Date: 13 February 2018
Our ref: 237833
Your ref: P/140/16/OUT

Planning consultation: Outline application for access only - mixed use development comprising of up to 400 dwellings, a care home with up to 70 beds, a Local Centre comprising up to 2000sqm of A1/A2/A3/D1/sui generis floorspace, provision of land for a 1FE primary school (with sufficient space to ensure that it is expandable to 2FE), provision of land for a scout hut, safeguarding of land to help link the site to the Pagham Harbour Cycle Route & other community uses including public open space & allotments with some matters reserved

Location: Land South of Summer Lane & West of Pagham Road Pagham

Thank you for your consultation, dated 29 January 2018, on the Brent Goose Mitigation Plan (December 2017).

Fig 1 – Eco 1

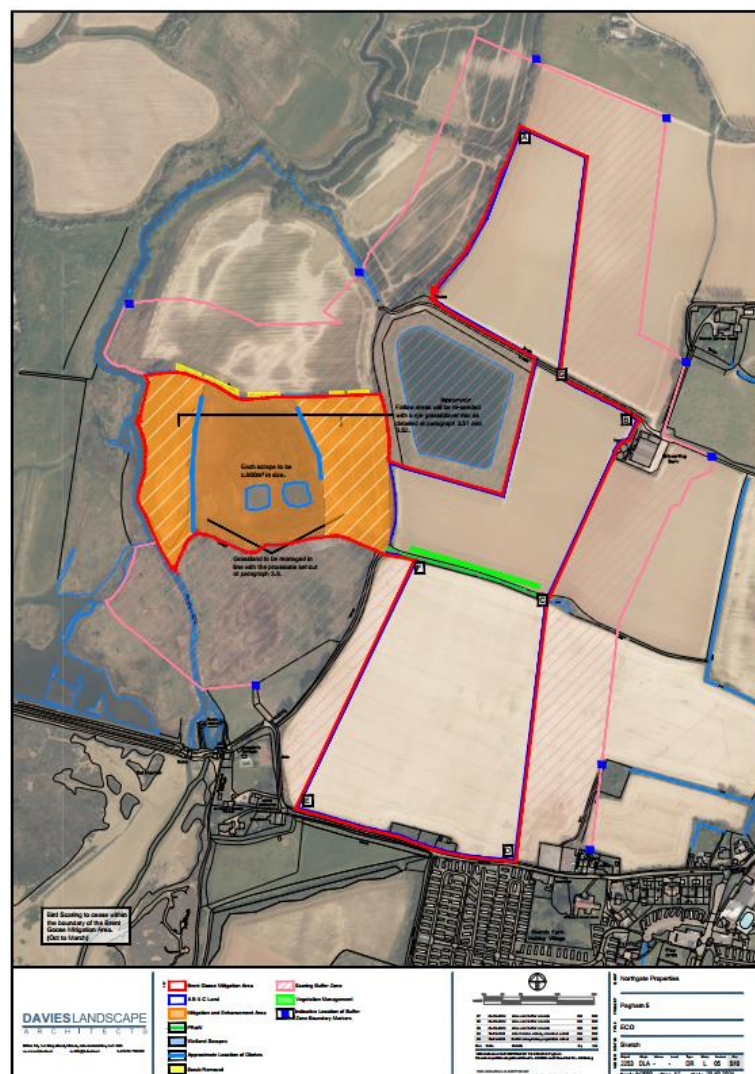
Natural England's view is that the location of the proposed mitigation land (shown at Plan ECO1 of the BGMP) is acceptable as it is closer to the SPA than the application site. It therefore, offers an advantage over the application site for foraging, as geese will expend less energy flying to the mitigation land from their roost site. A further advantage over the application site is that the mitigation land is not crossed by any footpaths, therefore is not susceptible to disturbance.

The cessation of bird scaring measures over the area described in Plan ECO1 is essential for the successful implementation of the measures described above, and would be an improvement over the current situation. However, this would not be the case if crops favoured by brent geese are planted less often than currently. Therefore, the Habitat Management Plan should include a commitment to planting winter cereals at an appropriate frequency in the rotation.
